RE: TCL Comments Samana Apartments 6501 Bataan SW

I am writing in response to the review comments dated March 3, 2025

DRAWING TITLE
TRAFFIC CIRCULATION LAYOUT

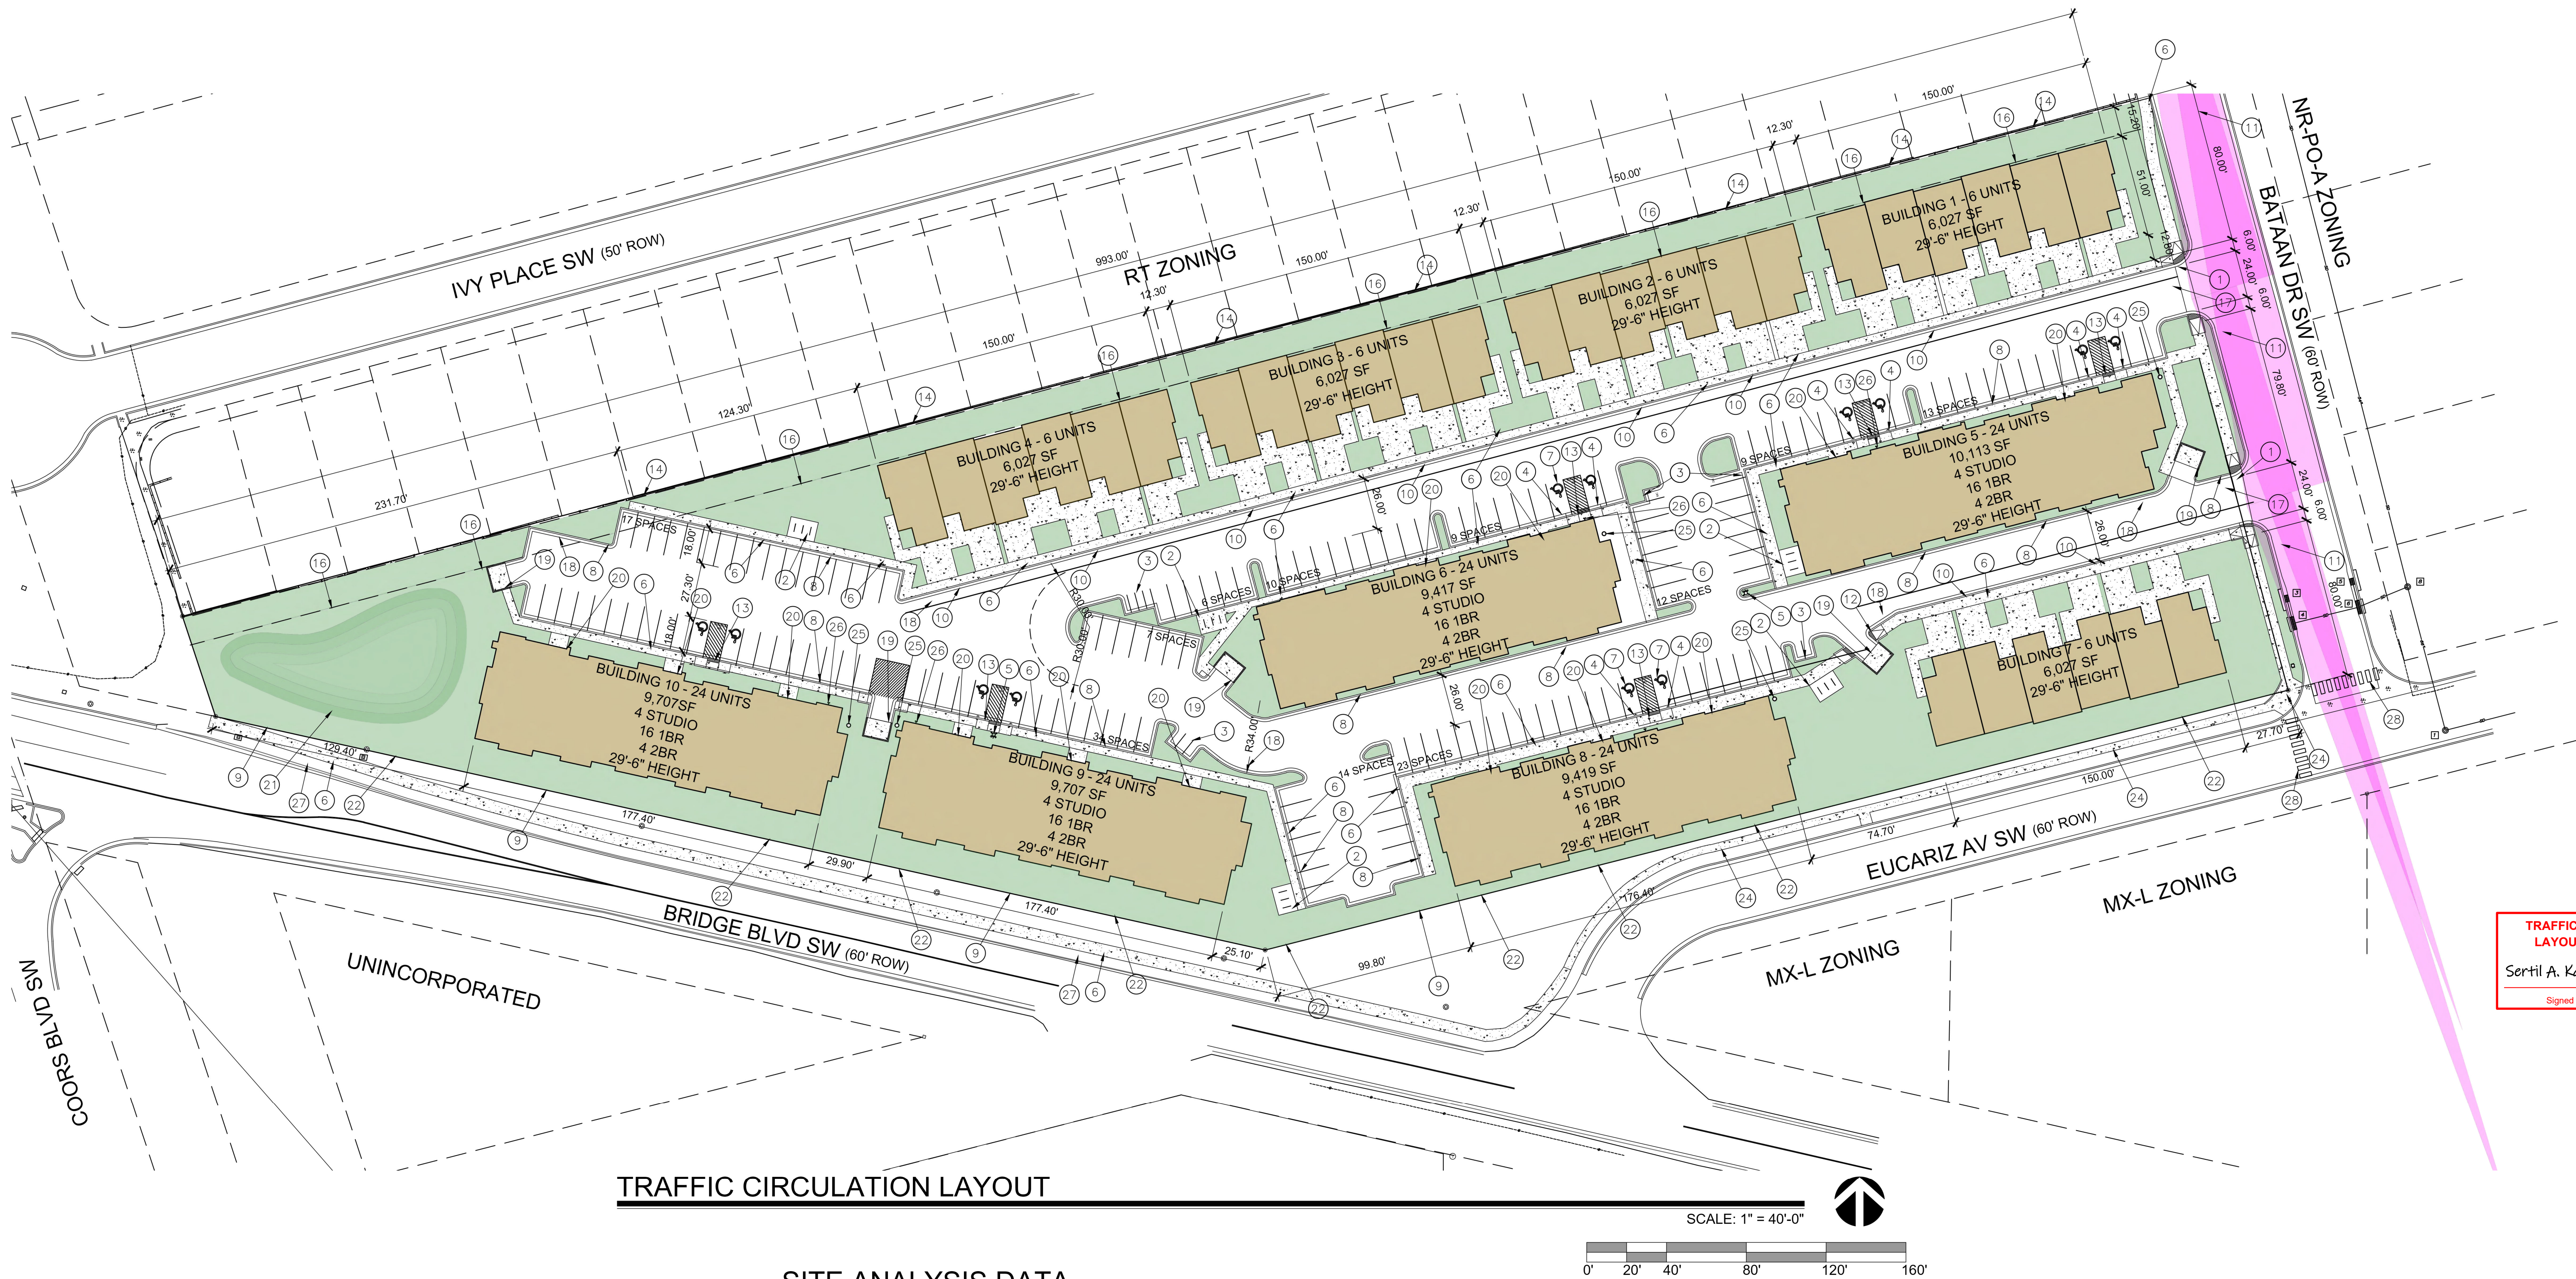
- 1) The PDF dots were removed.
- 2) Airport Dr. ROW added, there are no sidewalks on Airport, they are on Coors Blvd. The Survey is attached for your reference. The widths of sidewalks for all other streets added.
- 3) The street name was corrected.
- 4) Sidewalk and buffer dimensions added.
- 5) Crosswalks added.
- 6) Details moved to separate sheet.
- 7) Detail references corrected.
- 8) Sheet name changed
- 9) Noted.
